DECISION DELEGATED TO HEAD OF PLANNING

Application No: H04-0582-23 **Applicant:** Mrs R Welsh
Proposal: Erection of detached bungalow and garage - resubmission of H04-0632-20
Location: 4 Goxhill Avenue Donington Spalding
Terminal Date: 18th August 2023

Block Plan - Proposed

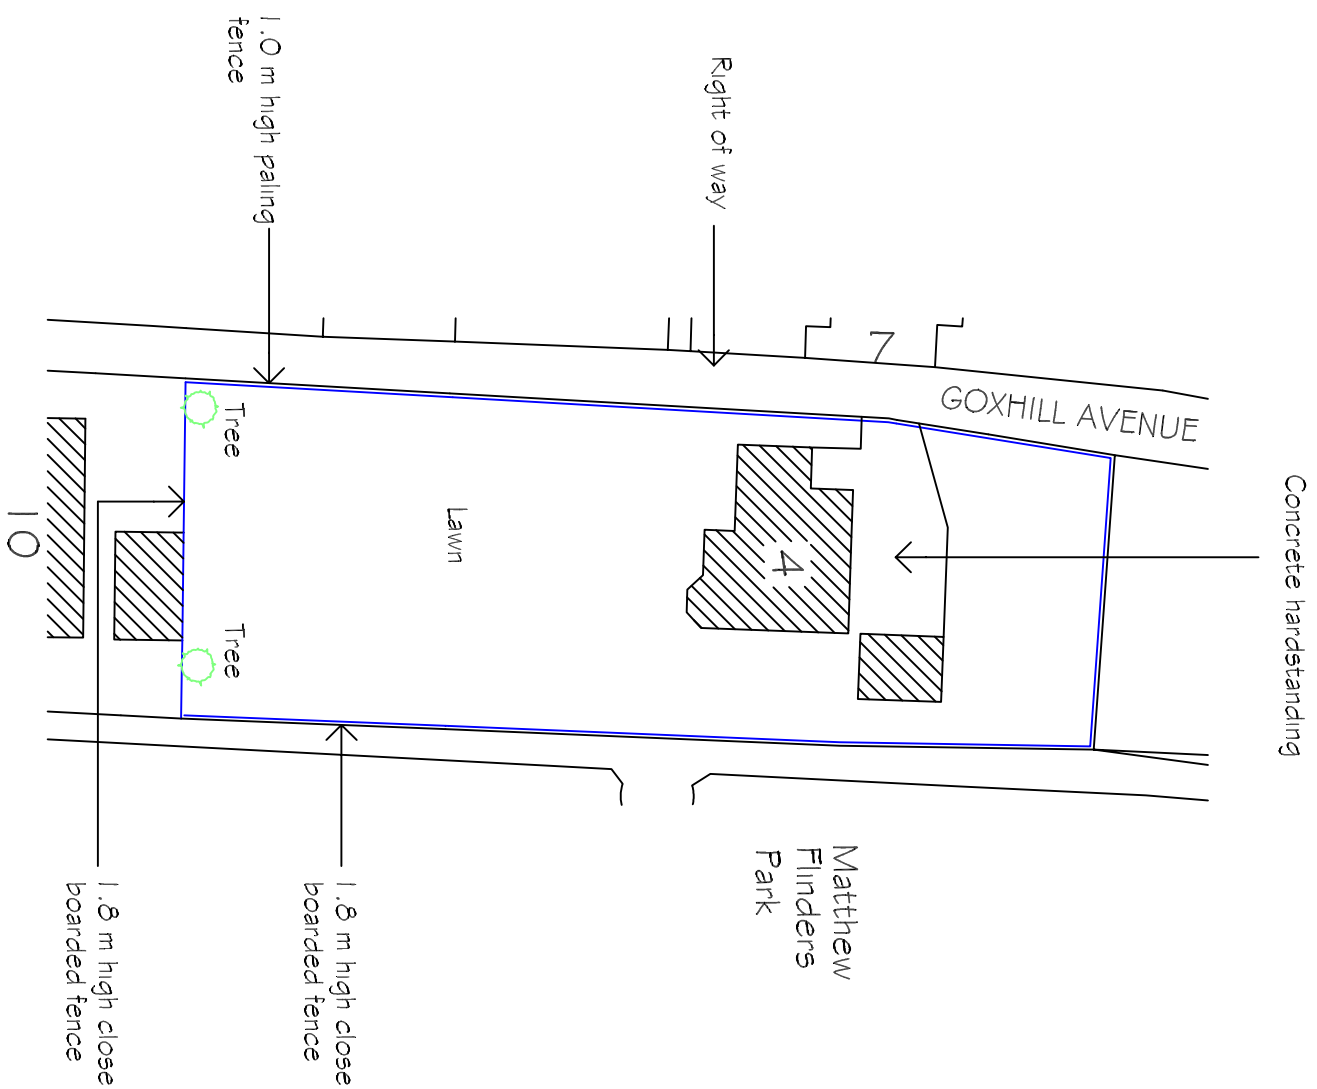
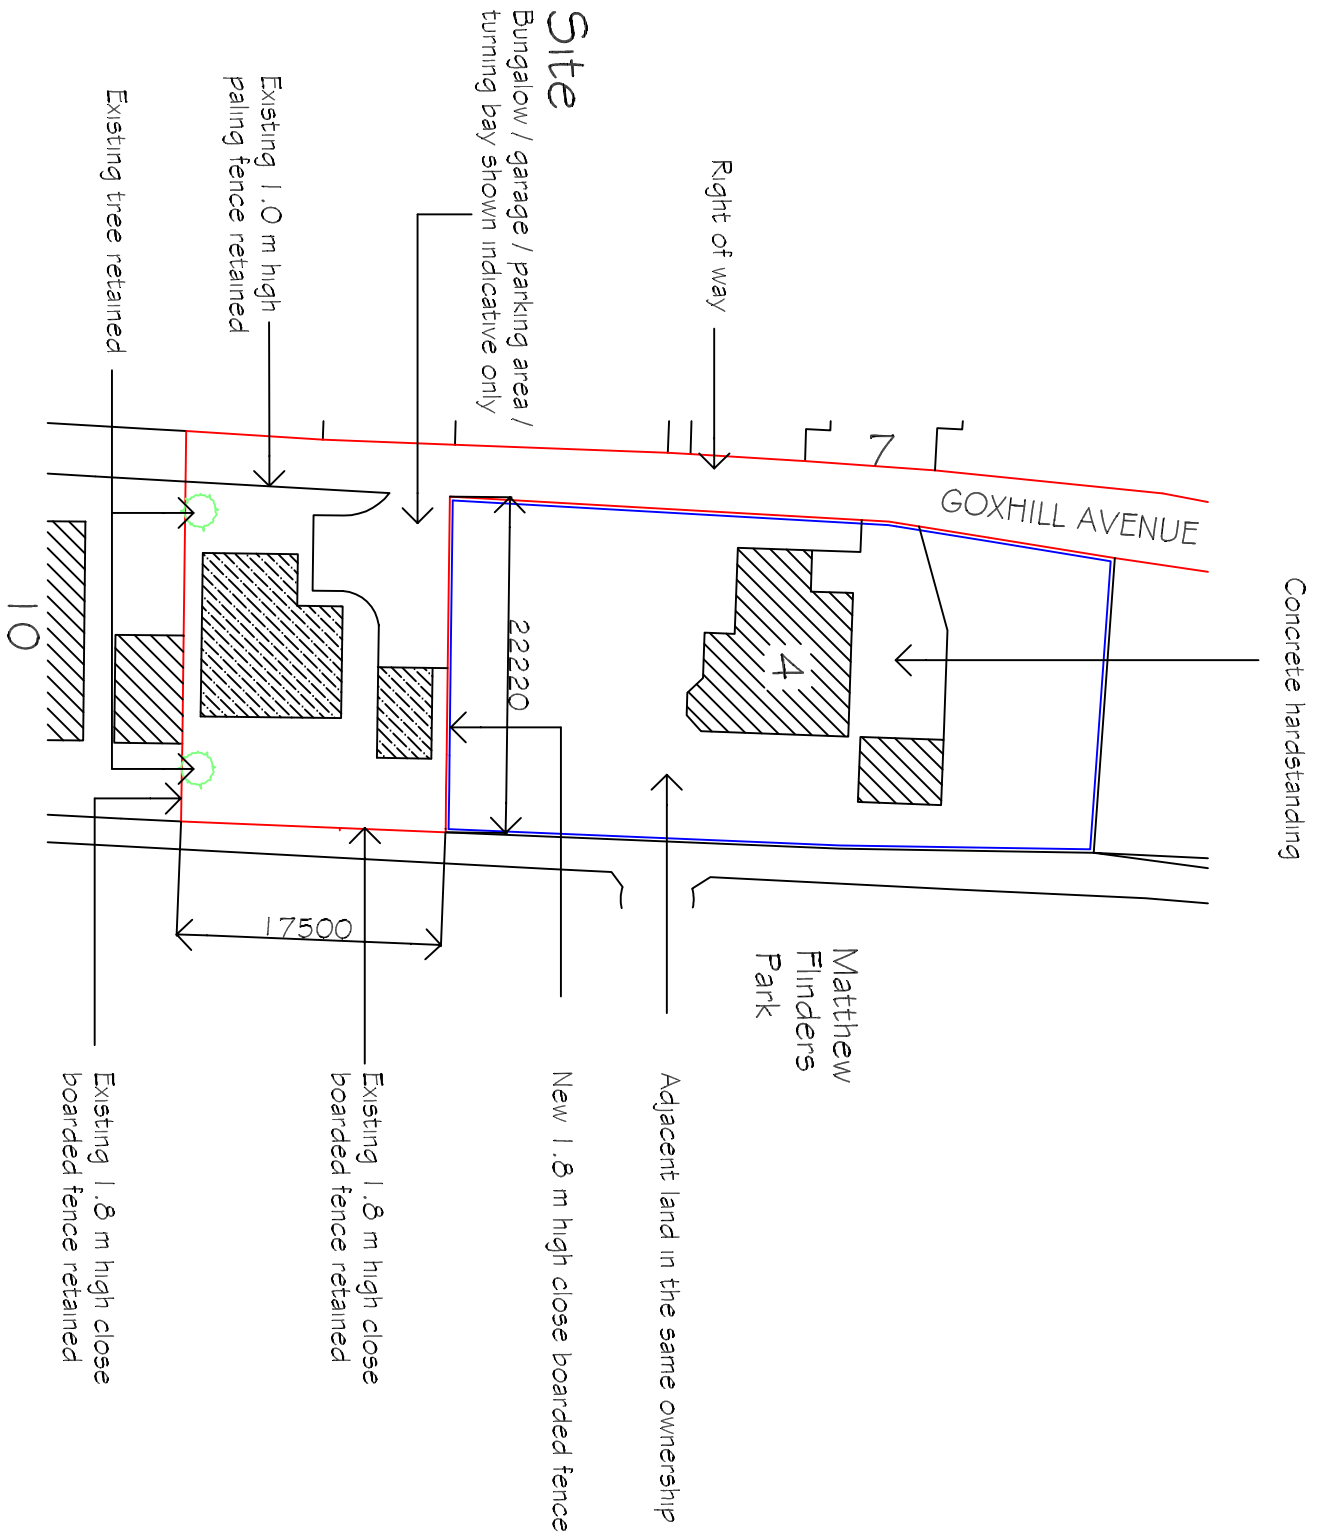
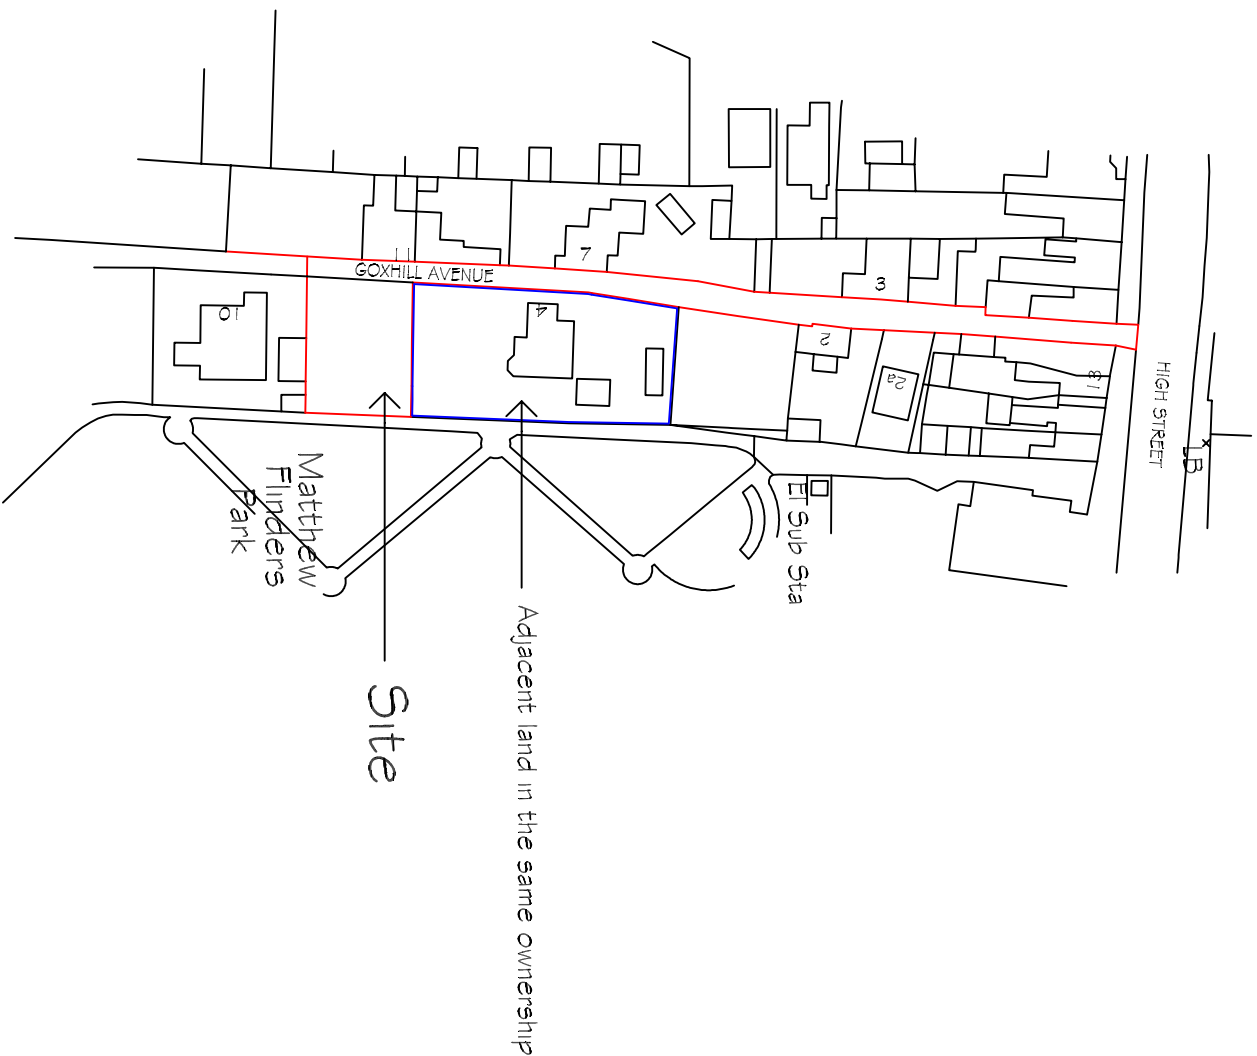
Two small cherry trees adjacent to the southern boundary are shown on Block Plan to be retained. Suggest that a Condition is worded to ensure that they are indeed retained as indicated so on the plan. Currently they have limited amenity value, but as it is stated that they are to be kept, this will certainly help the new development blend into its surroundings; readymade landscaping. It will be up to the Developer to ensure that the correct foundations are installed so that they will never cause damage as they grow.

The retained cherry trees will require the usual Conditions to ensure that they are protected to British Standard 5837:2012 from the onset of development to its completion. This may be challenging on a tight site, but should have been factored in when a decision was made to retain them.
